Written representation for Issue Specific Hearing 11 (ISH11) on Flooding, Water and Coastal Processes

5. Outline Drainage Strategy [REP2-033] Outstanding issues relating to the Outline Drainage Strategy:

Plate 3.9: Water Management Zone 6

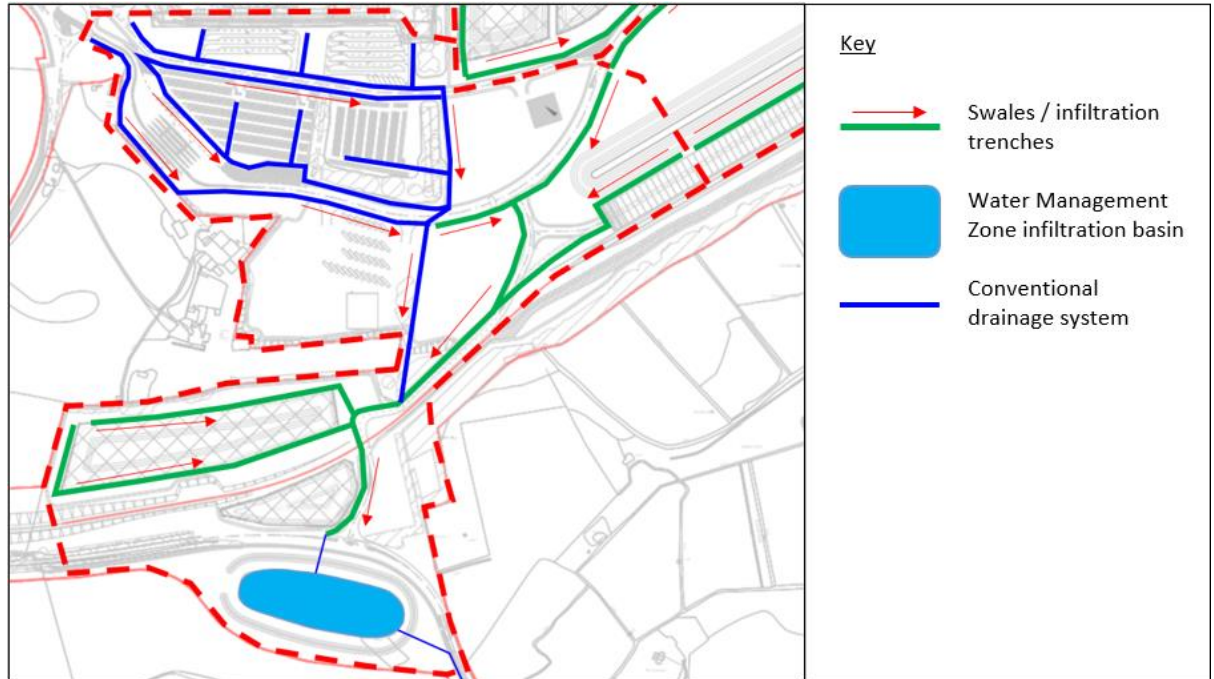
- The discharge rate from attenuation basins is proposed at 1l/s/ha which the IDB supports, however the discharge rates have been determined using the entire catchment of each WMZ. For example WMZ6 has a catchment of 47.77ha, and therefore proposes a discharge rate of 47.77l/s. However, the calculations only account for an impermeable area of 27.7ha (which still discharges at 47.77l/s). The consequence of this is that the remaining 20.06ha of the 47.77ha catchment is not represented in the model. Working on the assumption that the unrepresented 20.06ha continued to discharge as in the greenfield scenario, this greenfield discharge would runoff in addition to the 47.77l/s which is supposed to represent the entire catchment, therefore increasing runoff rates beyond the design. According to best practice we understand that either the greenfield runoff rate should be amended to represent only
